Response to Planning Application Further consultation comments 19/08/21

Application ref: A/26/21/RES

Description: Approval of reserved matters following outline consent A/44/17/OUT for appearance, landscaping, layout & scale for the demolition of existing buildings on site & erection of a mixed use development comprising of 90 No. residential dwellings & a care home & ancillary facilities including railway crossing together with associated access, car parking & landscaping. This application also lies within the parishes of Rustington & Littlehampton.

Location: Land west of Brook Lane and South of A259 Angmering BN16 3JL

Refer to drawing 176-012 for LEAP General Arrangement Plan.

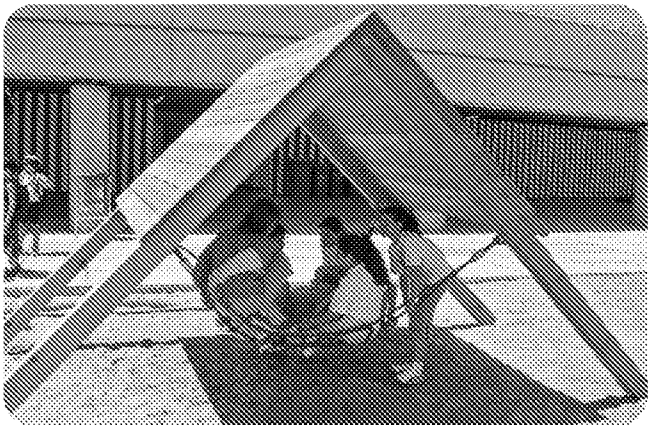
LEAP – provides a good play offer appropriately fenced and gated with a good selection of play experiences and play offer. The play area has proposed an inclusive element of play and is accessible with all-weather pathways. Note the LPA would not be supportive of the Tiger Mulch safety surfacing (assuming this is a loose fill woodchop/bark material) due to maintenance issues should the play areas be maintained by the LPA. A loose fill material would also not be appropriate surrounding/adjacent to the P3B inclusive Orbit roundabout. The LEAP layout plan also incorrectly denotes PB3 as a swing when it is a rotating item.

- 1. LEAP –** (drawing ref: 176-012) – *the tiger mulch safety surfacing is actually a bound surface. However, there are other products available therefore we have put in the key as "Bound rubber mulch surfacing". An example of such product is as follows: <http://www.rtc-safety.co.uk/rubber-mulch/>. The play equipment P3B the Inclusive Orbit is amended as a "Rotating" item in both the GA and in the document 176-G102.*
